## Preliminary Acceptance – Punchlist from DPW Stormwater

Project Name:	Liberty Tree Academy Filing 2
EDARP Filing Number(s):	PPR-20-018
ESQCP Number:	ESQ1941
Attendees:	DPW SW: Joshua Augustenborg, Ben Jones, and Christina Prete DPW Planning: Brad Walters and David Parkerson Permit Holder: Jesse Schuckman
Date of Walk-Thru:	January 17, 2023
Walk-Thru Number:	1

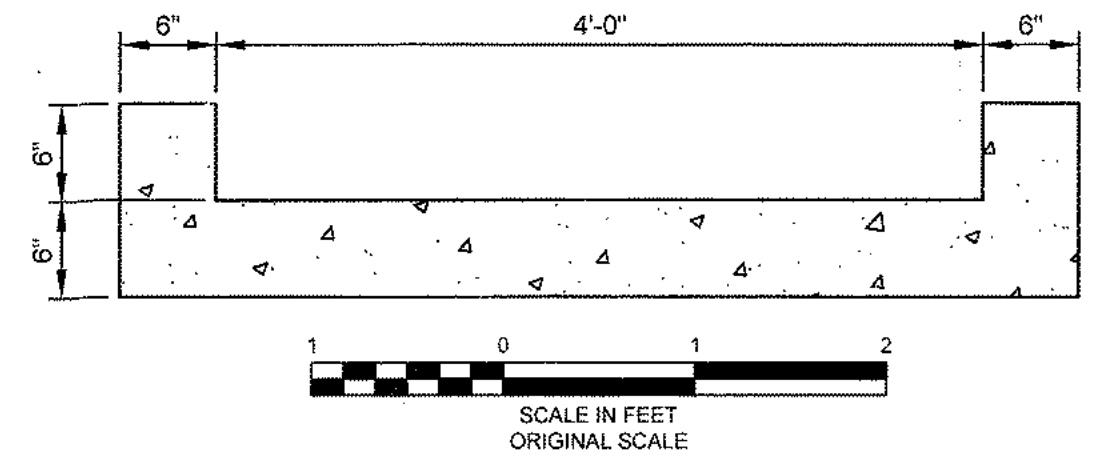
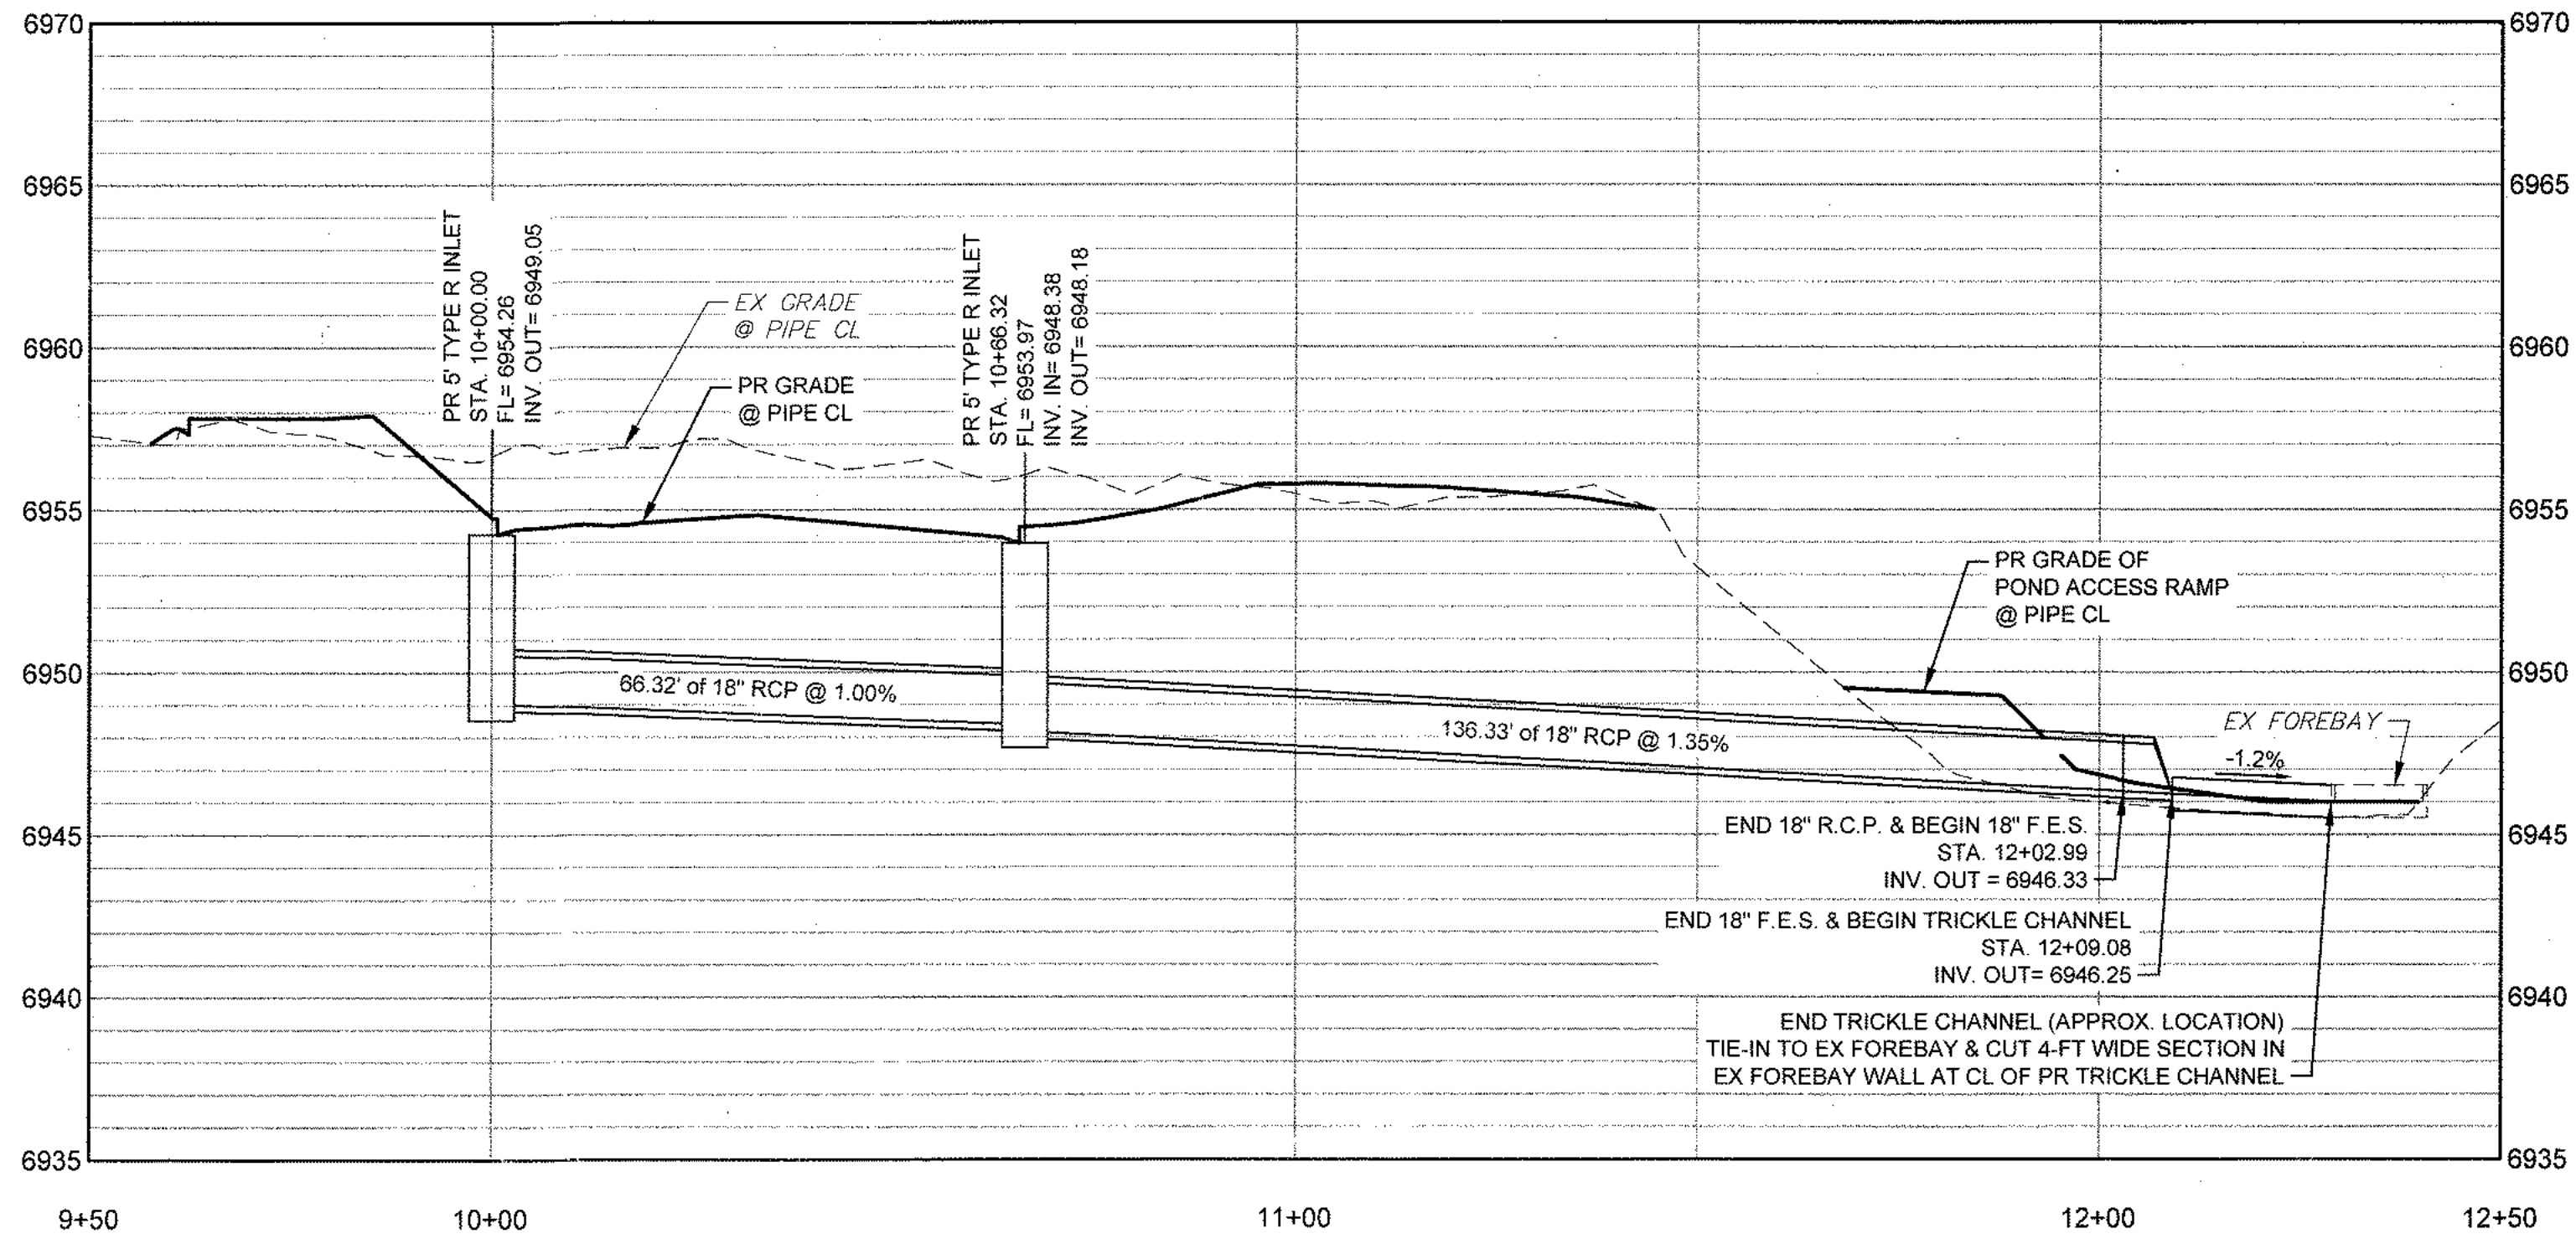
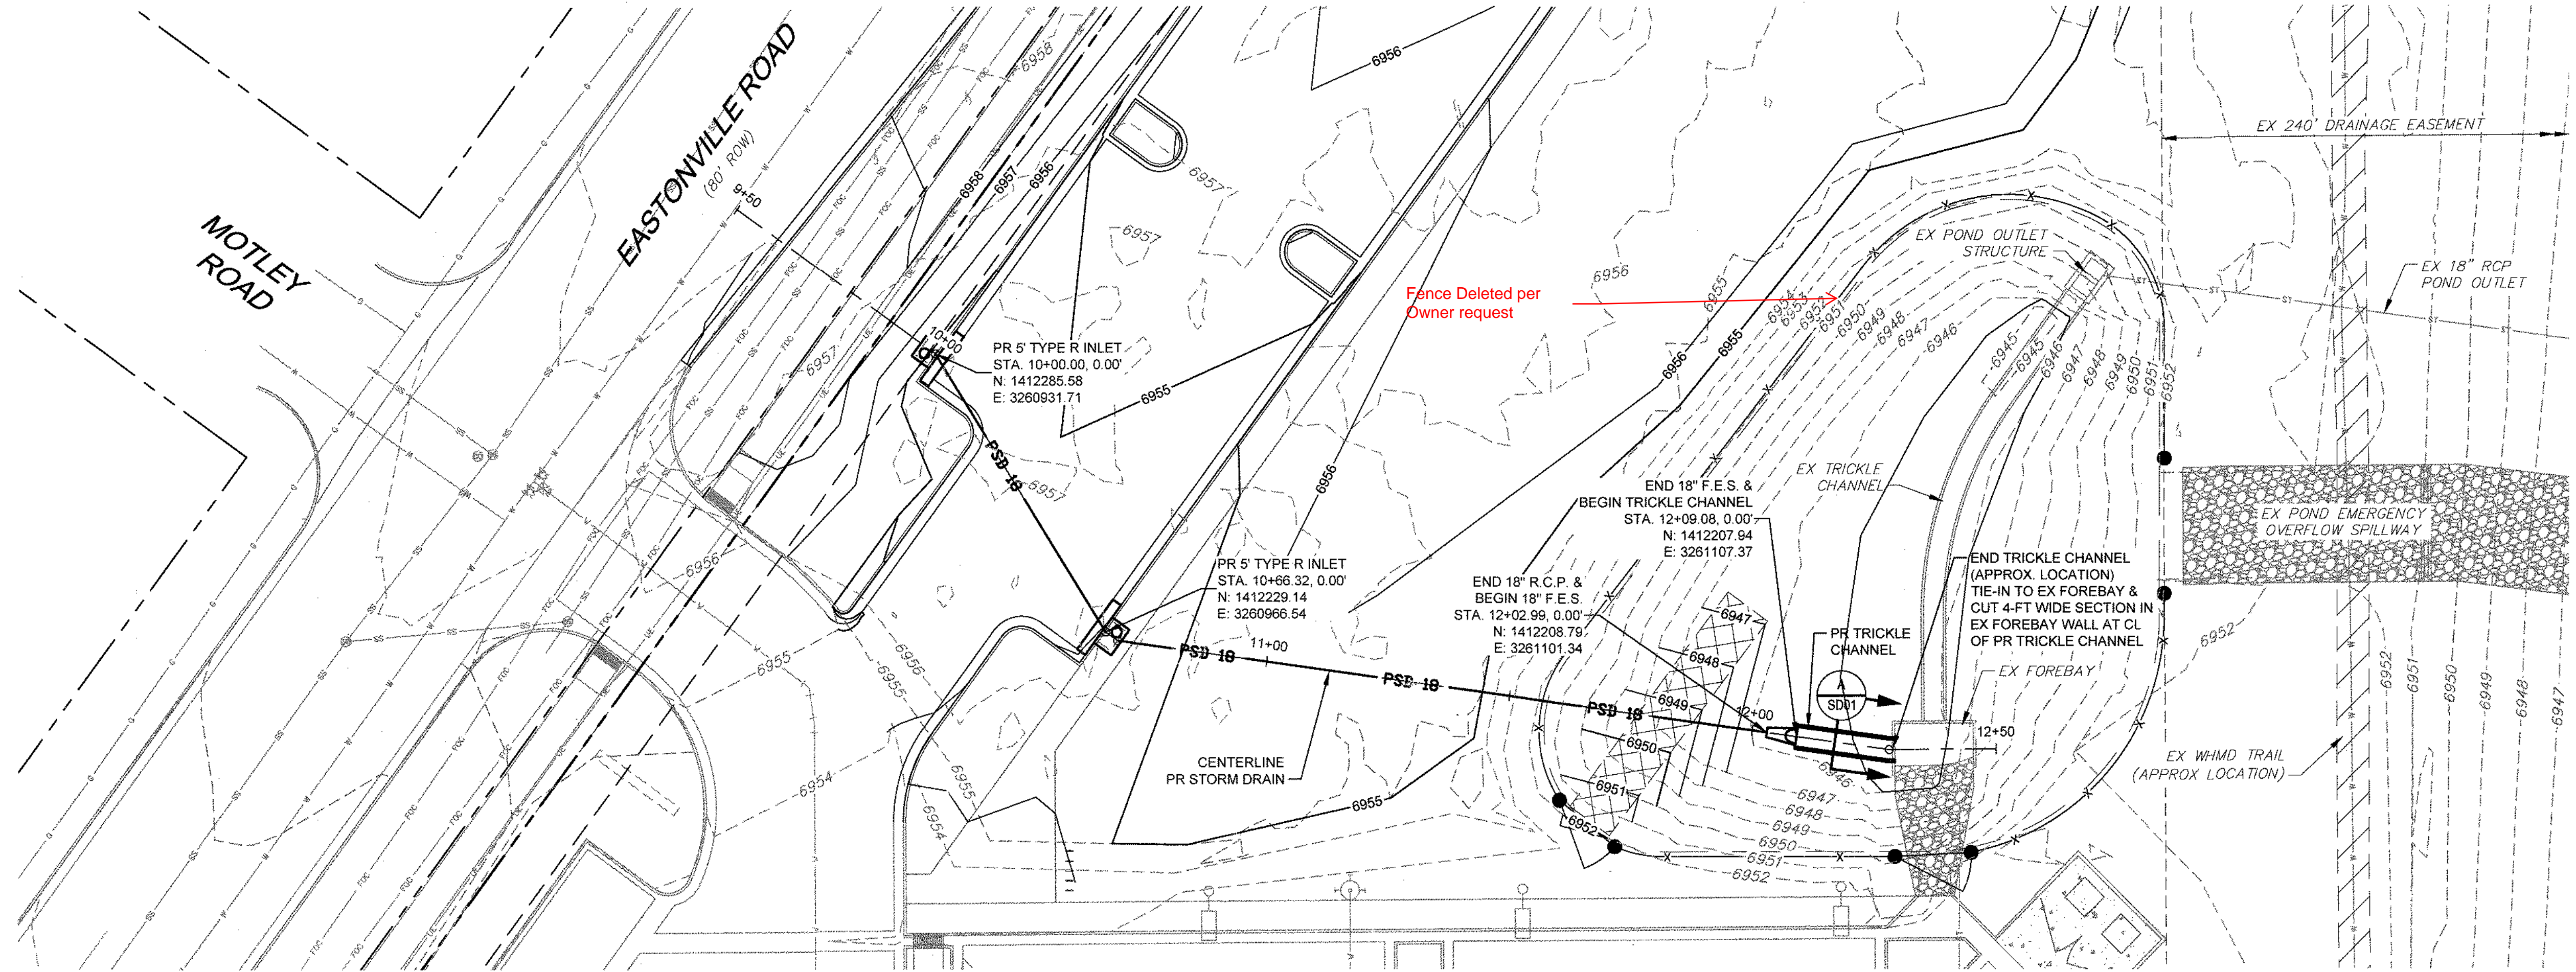
- Install Pond maintenance access road (min 10' wide, 54 LF). Stabilize with Class 6 Road Base, fiber reinforced concrete, or reinforced grass pavement. Reference Construction Drawings Sheet 7 of 19.
- Please provide Pond Certification Letter and As-Built Drawings to EPC for review and approval.
